ATTACHMENT H

Utility Capacity Information

March 14, 2014

Attn: Bo Kennedy, P.E.
Re: The Forefront at Thompsons Point, Portland
Ability to Serve Project with PWD Water and Wastewater

PROJECT: THE FOREFRONT AT THOMPSON'S POINT
 SHEET TITLE: UTILITY PLAN - EAST
 CLIENT: FOREFRONT PARTNERS I, LP

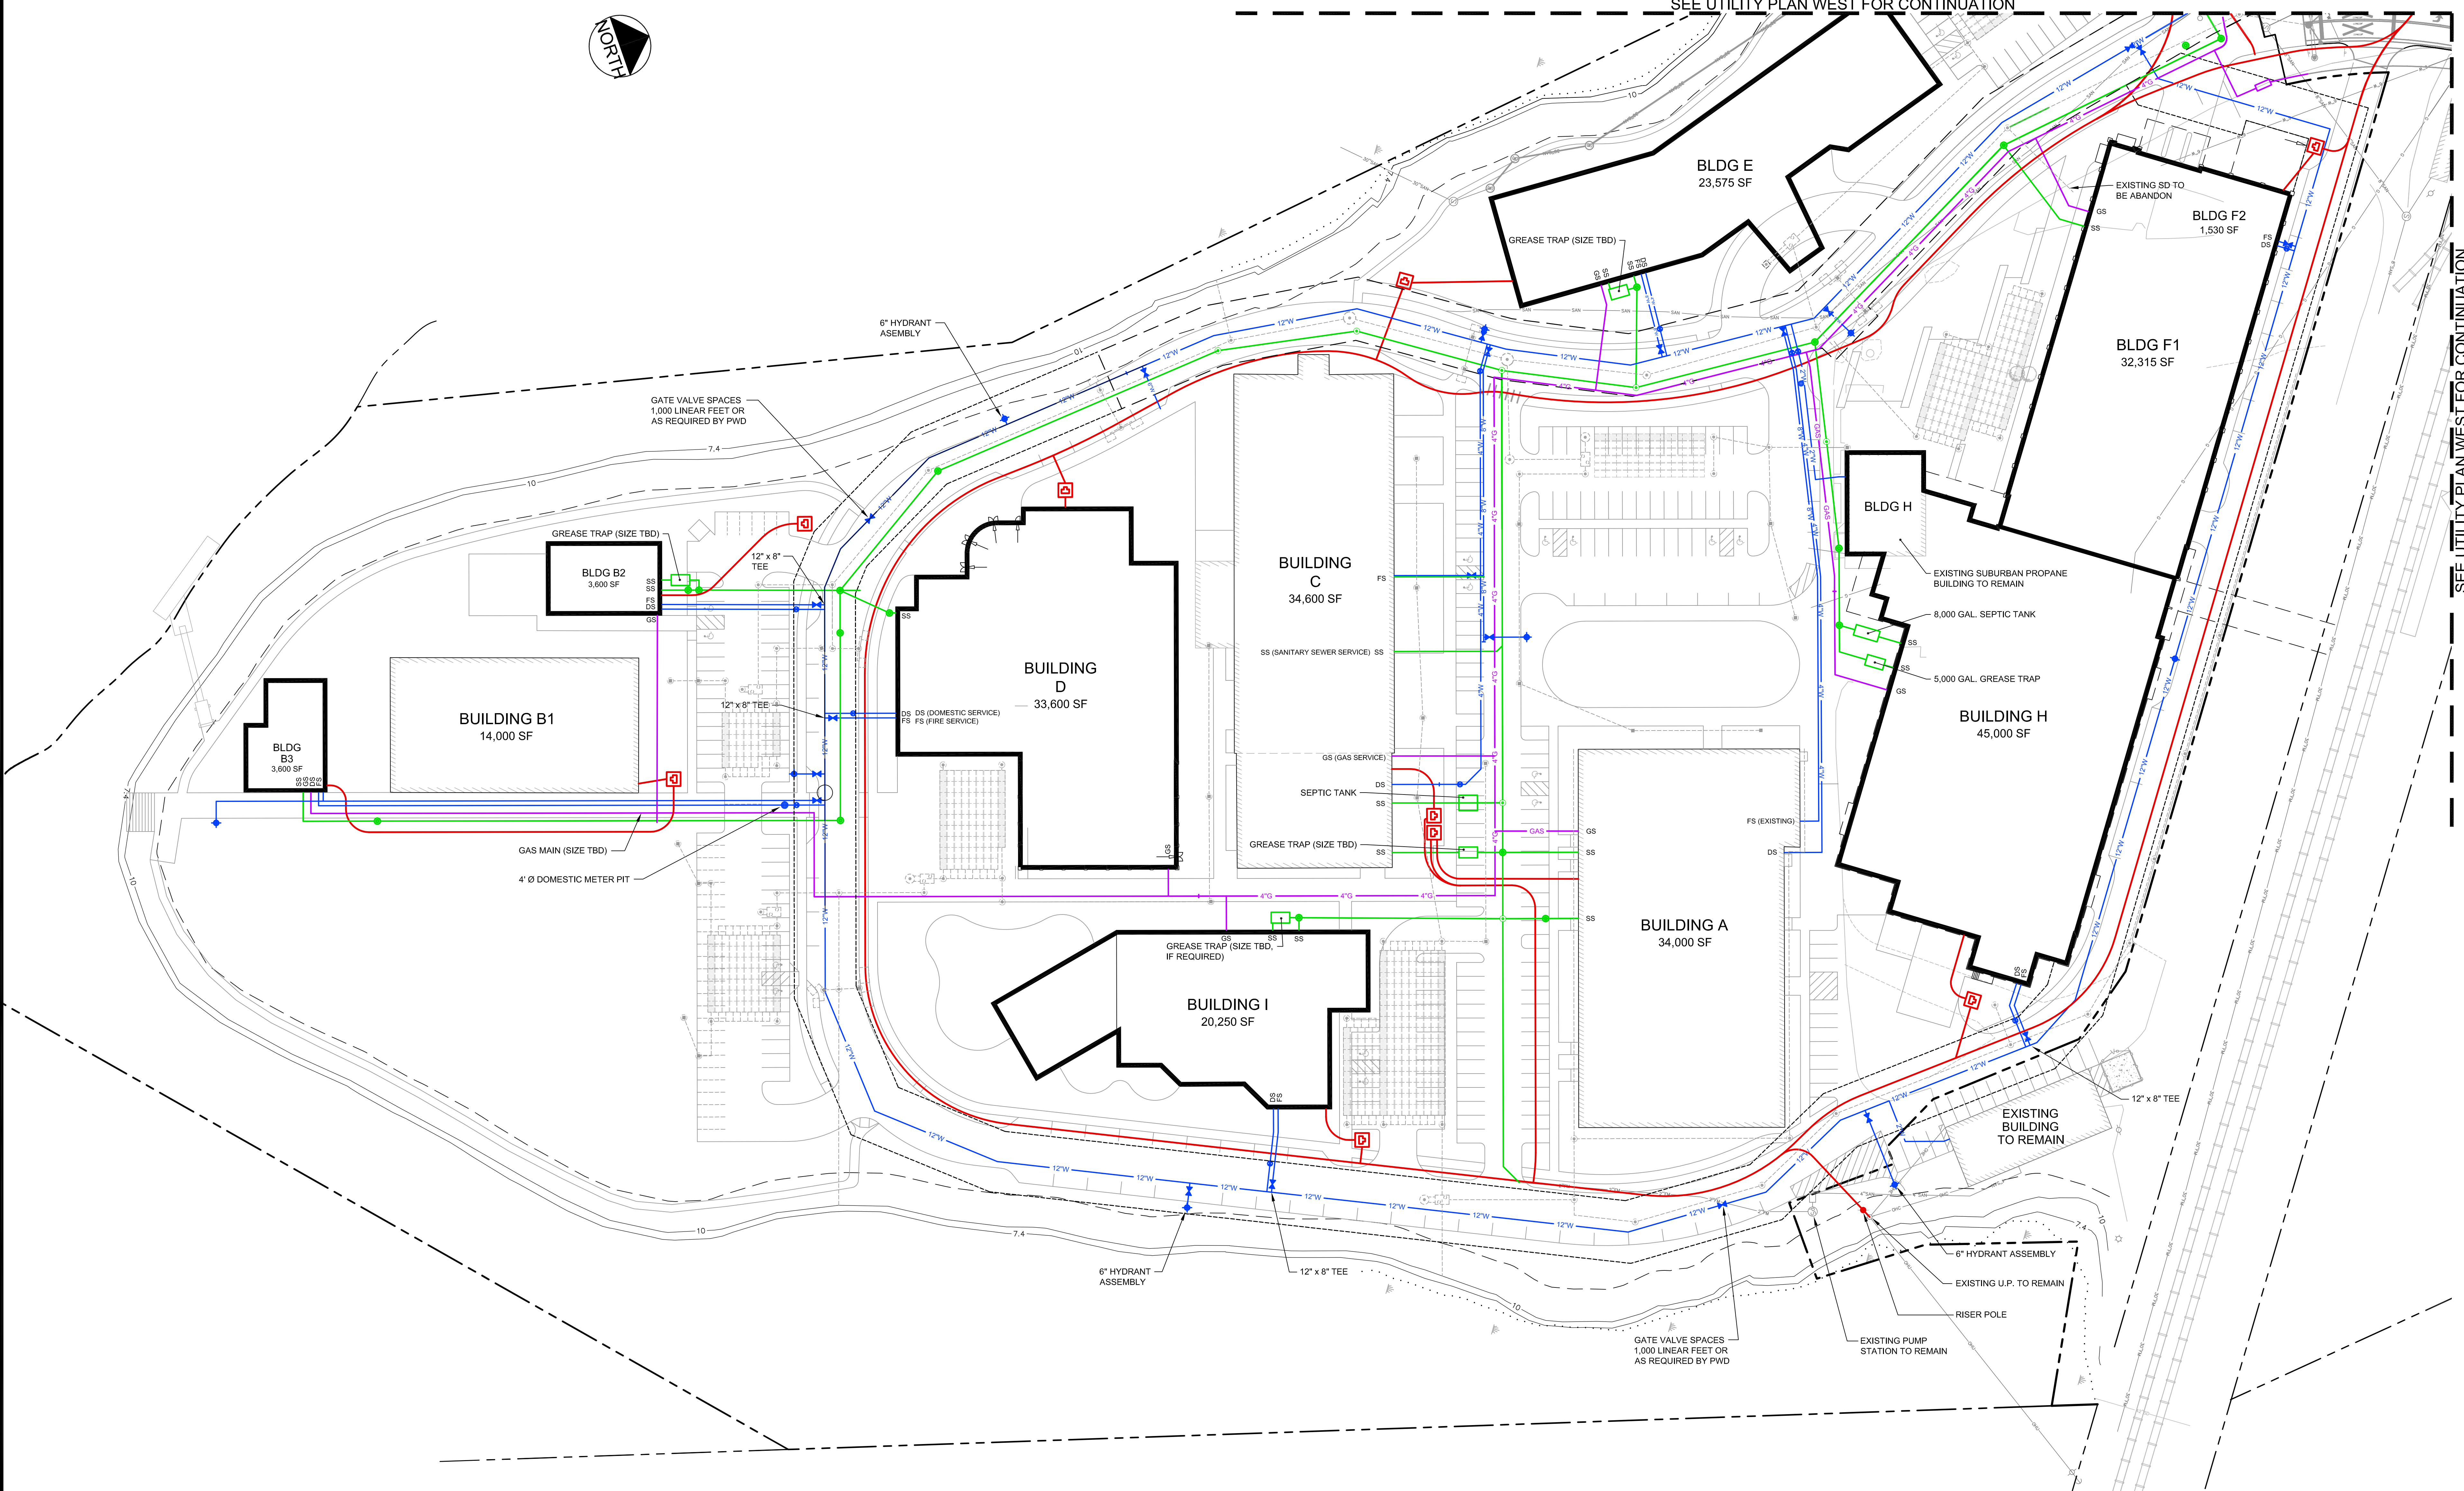
2. Access to the Thompson's Point pump station appears restricted and does not appear to allow for adequate space for our vehicles to turn around. We will require that the final design include a turnaround within the pump station site for PWD vehicle use.

4. Based on an anticipated high level of foot traffic near the pump station site, further review of the site security is required. Fencing of this site is recommended for the protection of the facilities and the pedestrians. The developer may also wish to work with PWD on the general aesthetics of the pump station facility to better match the character of the final site.

5. The proximity of the 30" CSO Outfall in relation to the foundation for Building E1 should be reviewed. More information on separation from the building and the process for any maintenance should be outlined.
